OXFORDSHIRE COUNTY COUNCIL'S RESPONSE TO CONSULTATION ON THE FOLLOWING DEVELOPMENT PROPOSAL

Interim Response

Application no: 23/01233/OUT

Location: OS Parcel 4347 East Of Pipal Cottage, Oxford Road, Kidlington.

Figure 11 – Illustrative Masterplan

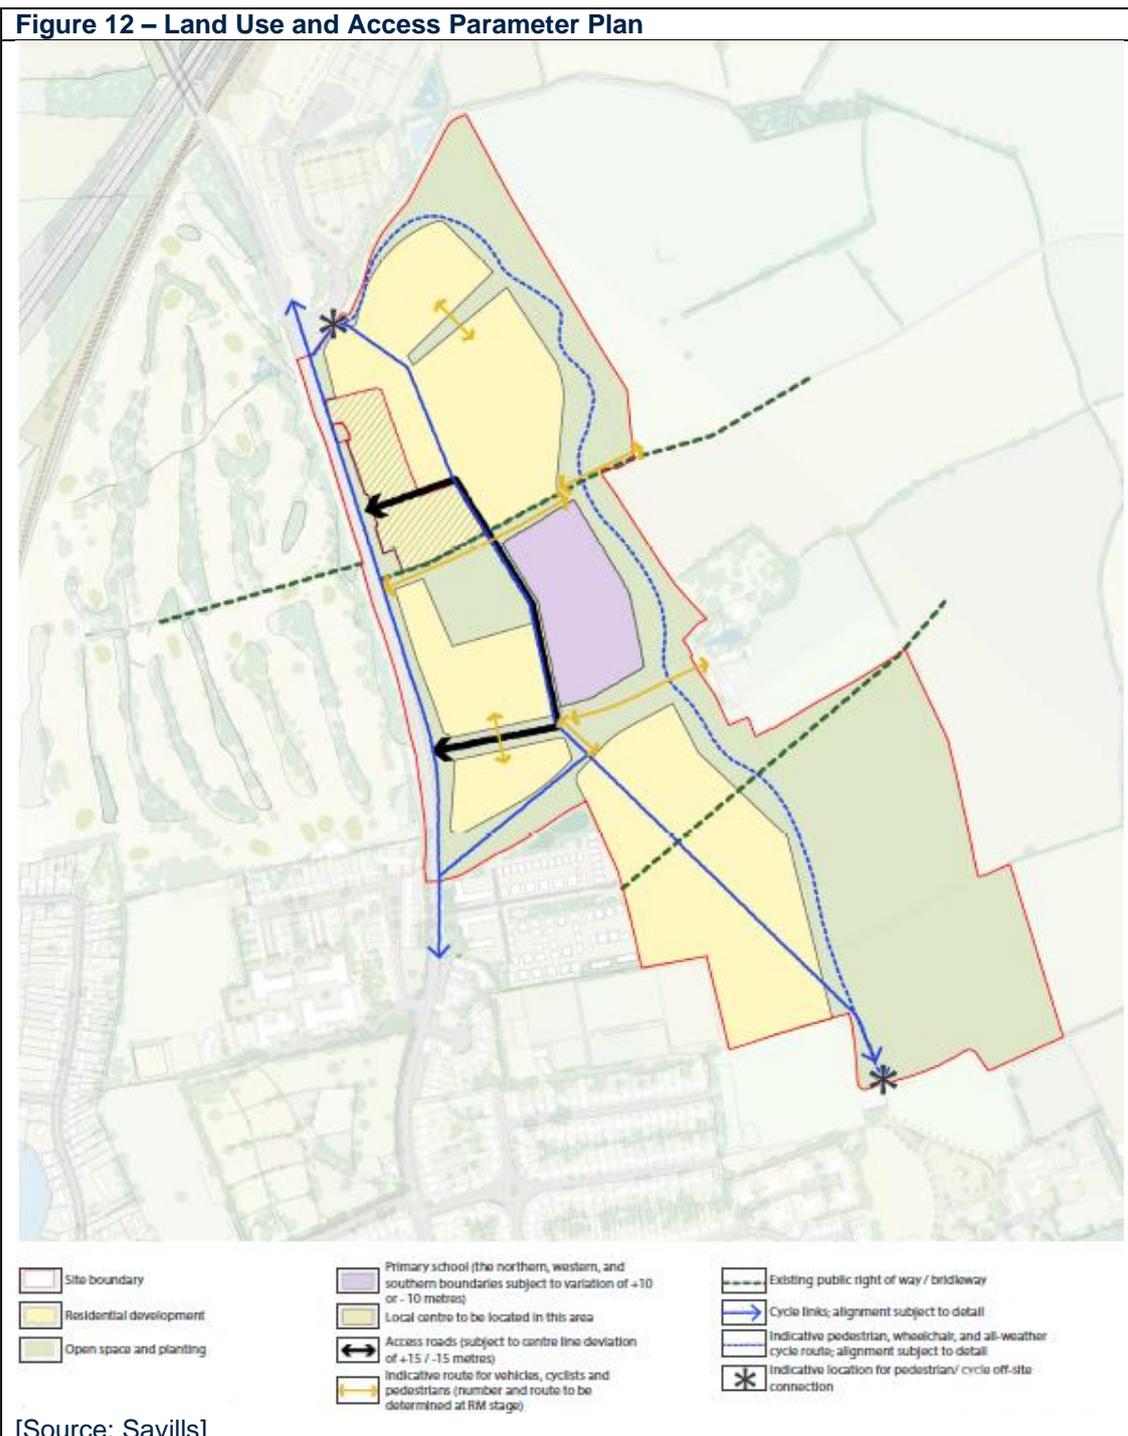
The proposal to locate the Primary School in the centre of the site is generally supported. It is sufficiently dispersed from the already established Cotteslowe Park Primary School to the south-east and located centrally within the development and in close proximity to the local centre.

The application documents and drawings refer to a 2.2ha Primary School. OCC's requirement for a 2FE Primary School is 2.22ha. However, due to the significant level change across the proposed school site, a site area greater than 2.22ha will be required. Unusable area such as the banked circulation route between the two plateaus are not to be included within OCC's area requirement provision. This is to ensure that the site operations are not constrained.

The shape of the proposed site is generally in line with the proportions OCC would expect of primary school sites, however the location of the green corridor to the east of the site and the barrows to the west constrain the width of the school site. Site dimensions are required to confirm that the shape and proportions are in line with OCC requirements for a 2FE School.

It appears that there is sufficient room for a 2FE Primary school footprint with accommodation on 2 storeys. External areas inclusive of hard play, habitat, playing field, car parking, service areas and pedestrian circulation all appear to be possible to include satisfactorily within the defined school boundary. However, any further width restrictions on the site would have a detrimental impact on the layout of the school building and external hard play.

Main vehicle site access is shown to the west side boundary along with secondary accesses further along the western boundary enabling access to the upper and lower plateaus and an access to the northern boundary. Further clarification is required regarding connectivity of the northern vehicular access to the school site from the neighbouring road network to ensure that it conforms to OCC's requirements.

The vehicular access points are to be 6m wide with 2m pedestrian paths either side. These access points must abut adopted highway and the locations shall be agreed with OCC and set out on s106 obligation plans.

The applicant will need to demonstrate that the proposed levels around the school site shall create level access into the school site, both vehicular and pedestrian and will create a level access to the school building no greater than 1:21. All levels will need to be agreed and set out on s106 obligation plans.

An indicative proving layout drawing no. 477898 – 47E was initially developed with the applicant and OCC which indicates the overall building position and surrounding external areas. A more detailed proving layout is required to demonstrate that 2.22ha can be accommodated (excluding the land lost to provide for the access between the two plateaus) and to determine the overall site requirement.

To address the level issues of the school site, two level plateaus have been created. Given the overall shape of the school site, there is sufficient room for the main building running east to west, staff car park, service area, and some external

play on the upper plateau. The 8400m² playing field is positioned to the south on the lower plateau.

Access between the two plateaus will need to be designed to meet Part M requirements.

More detailed level information would be required to verify that the levels of the playing field are compliant with Sport England requirements.

Coach parking for the purposes of school trips (to support 1 coach) has been included on the highway to the western boundary road within easy walking distance of the school building and pedestrian accesses into the school. Confirmation however is required that the off-site coach drop-off is sited within a layby.

Verification required that the 3 storey residential houses adjacent to the northern boundary are in accordance with OCC school design guidance for daylighting standards.
